From: Simon Davis
Sent: 06 October 2020 10:51
To: Kate Little [REDACTED]
Cc: Sam Pinkus [REDACTED]
Subject: RE: Y/72/20/RES Stakers Farm

Subject: Y/72/20/RES Stakers Farm

"Also, of note is a potential issue regarding the landscaping and part of the boundary with the neighbouring listed building (Stakers Farm and barns). It is believed that a stretch of the shared boundary is open and that as a result, some form of walling will be required in order to divide the two sites. Details of the means of enclosure should be provided, ideally in the form of a wall to match the existing."

REV	DESCRIPTION	DATE	AUTHOR	CHECKD
CLIENT				
dandara new homes				
PROJECT				
LAND AT NORTH END ROAD YAPTON				
DRAWING				
BOUNDARY TREATMENT LAYOUT 70 UNIT SCHEME				
SCALE 1:500 @ A1		DATE 02.08.19	AUTHOR LAH	CHECKED -
JOB NO 102-70		DRAWING NO PL-07	REV -	REV -
BRIMSTONE DESIGN LTD

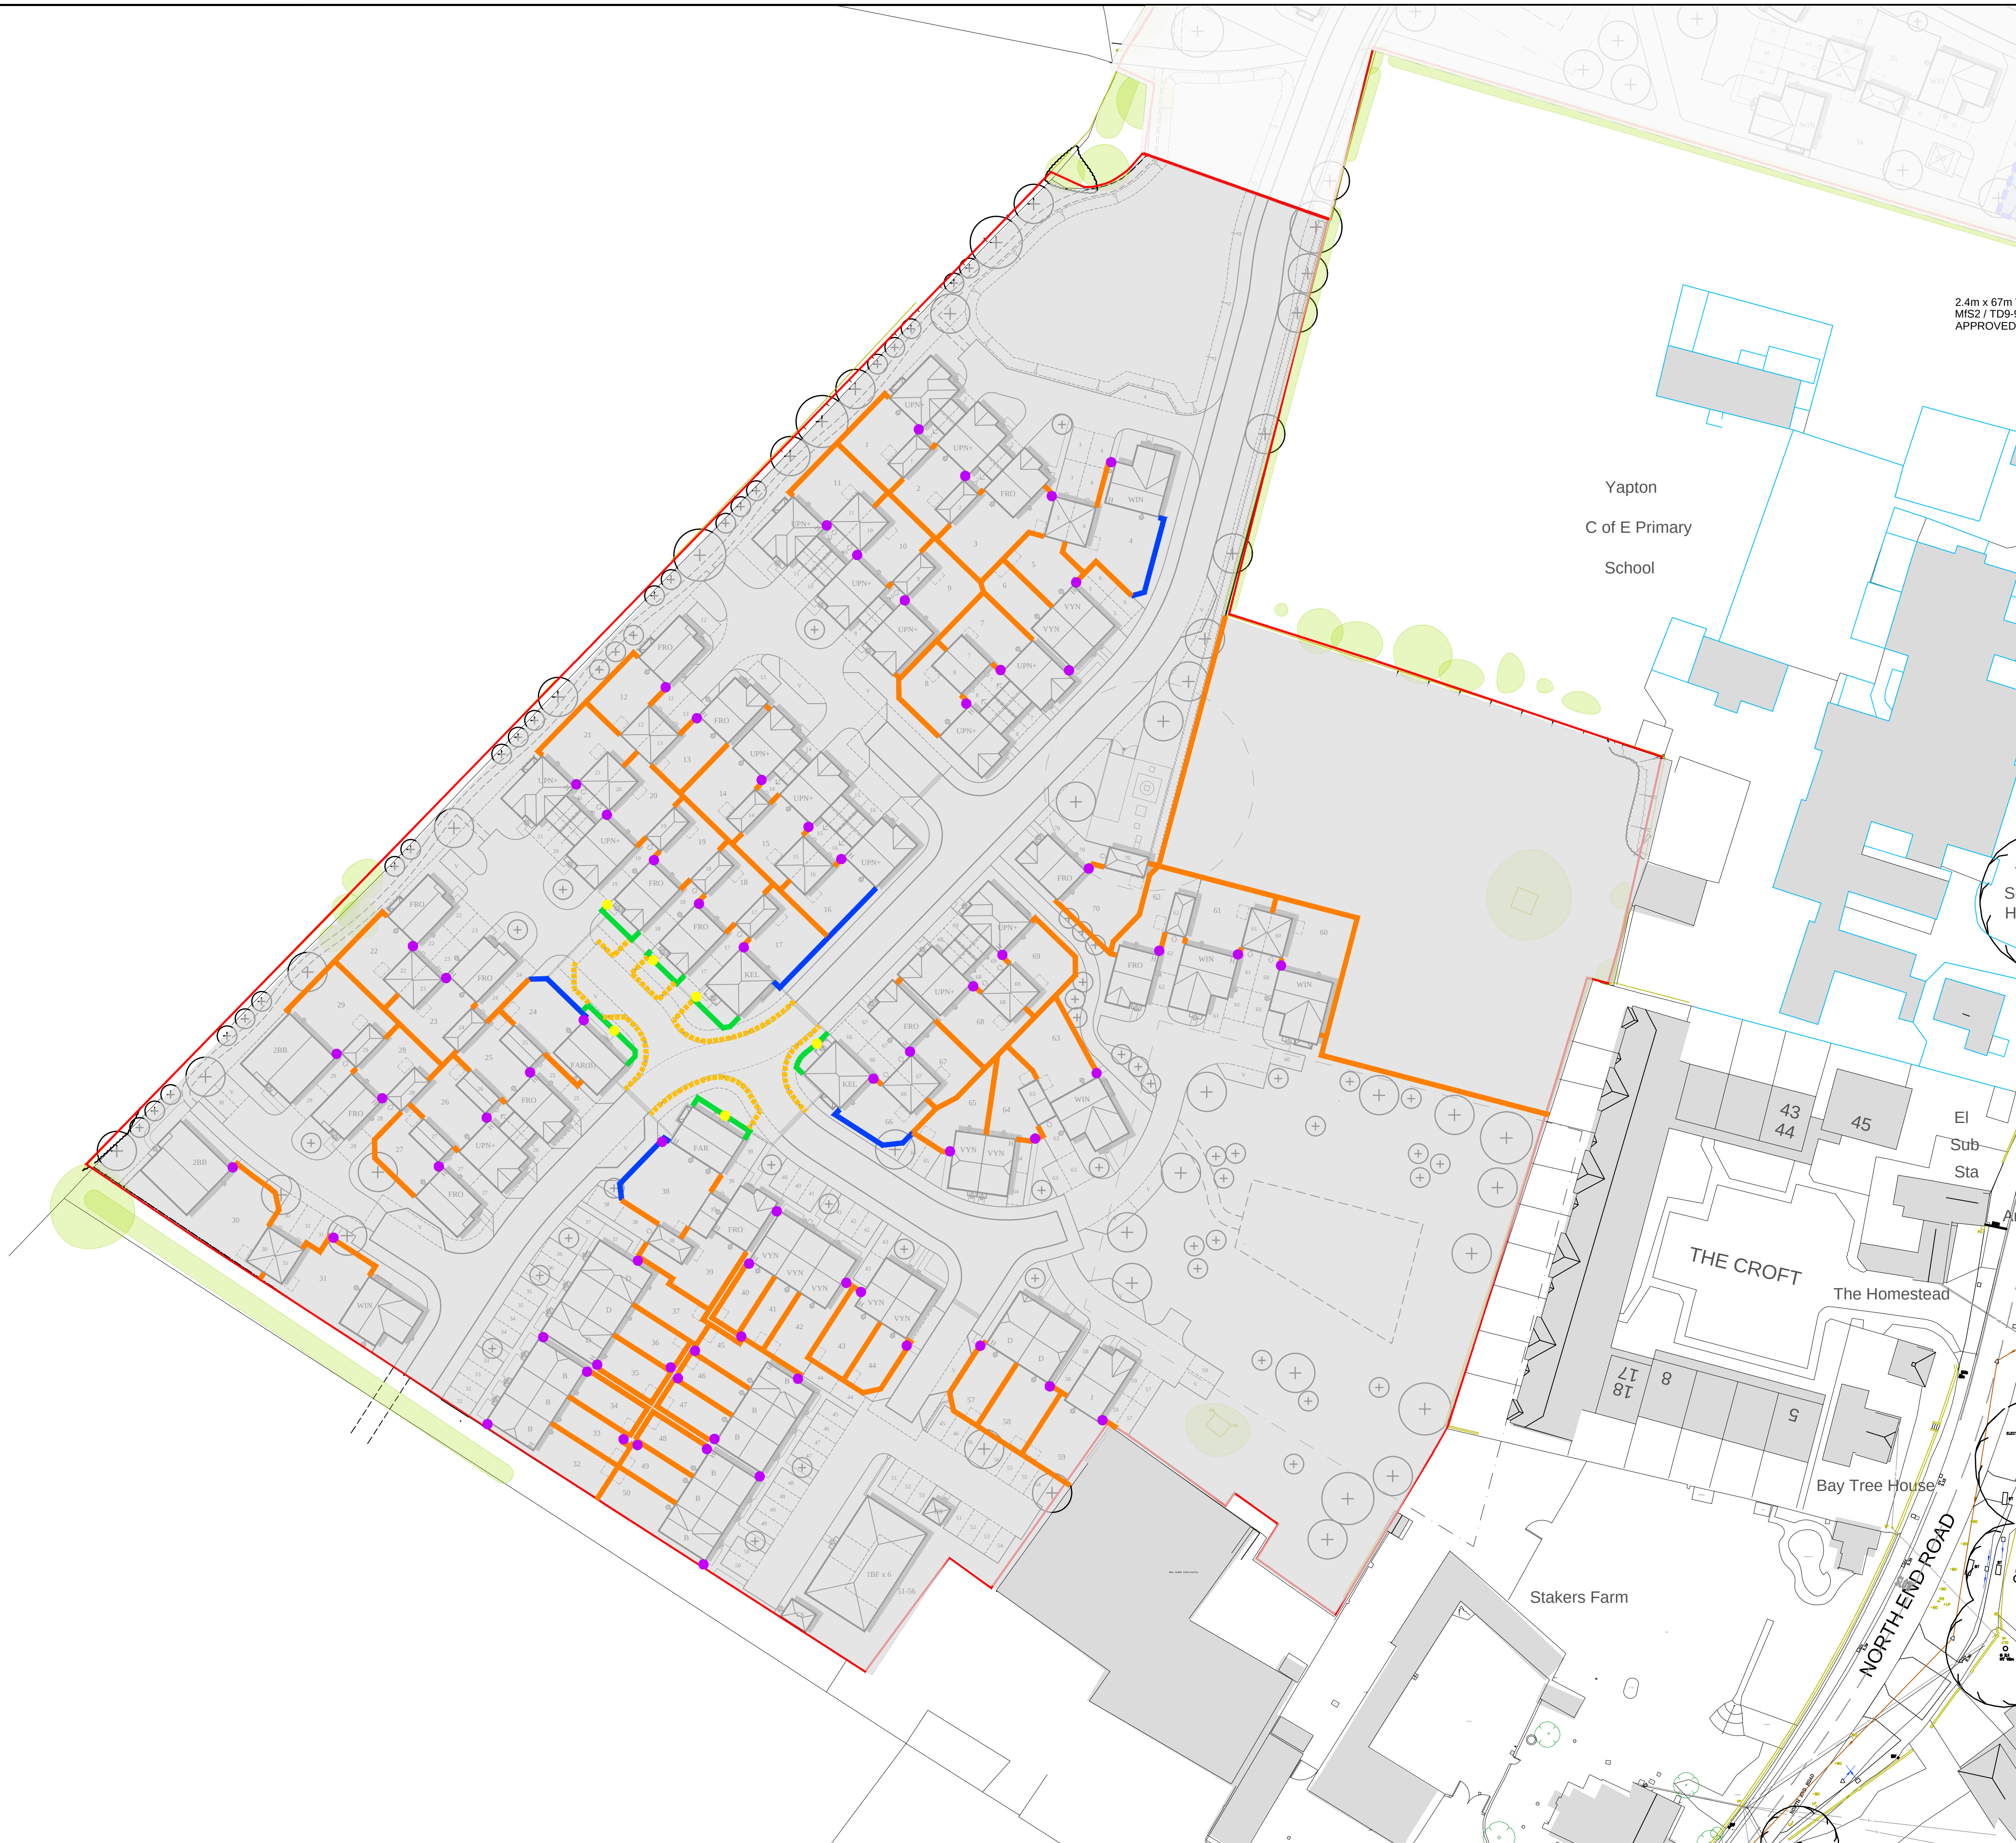
I have spoken with our Conservation Officer. He says that the proposed height of the infill wall would seem logical, but it would have to be carefully considered in the context of the lower section of walling to the south, which also appears to open onto the proposed open space. In that regard, would the landowner not want the whole wall raising?

I have looked at your Topo (SE corner near Stakers Farm buildings) and it does appear to show a gap between an outbuilding and the existing wall around the retirement home complex. This is also apparent on the attached photo I took in June 2017 (attached). In this photo, the gap is beyond the ranch style fence. The boundary treatment plan as provided does not reference any proposed new boundary along here.

Apologies, I should have sought confirmation from the landowner prior to making suggestions! There's an existing fence line which separates the area in question with land used as garden - in the position traced in blue below. As such we're happy to build the infill wall to a height to match the lower section of walling to the south and in materials to match?

A colleague has visited the site today (too wet for me!), first image below shows the area in question. The heras fencing, erected to facilitate the archaeological investigation, is set on our red line boundary. Happy to propose a wall in this position, we'll ensure amended proposals include this. Materials to match those in the second image from further along that boundary line. Would you be happy with a height of 1.8m? I suspect the landowner may request this.
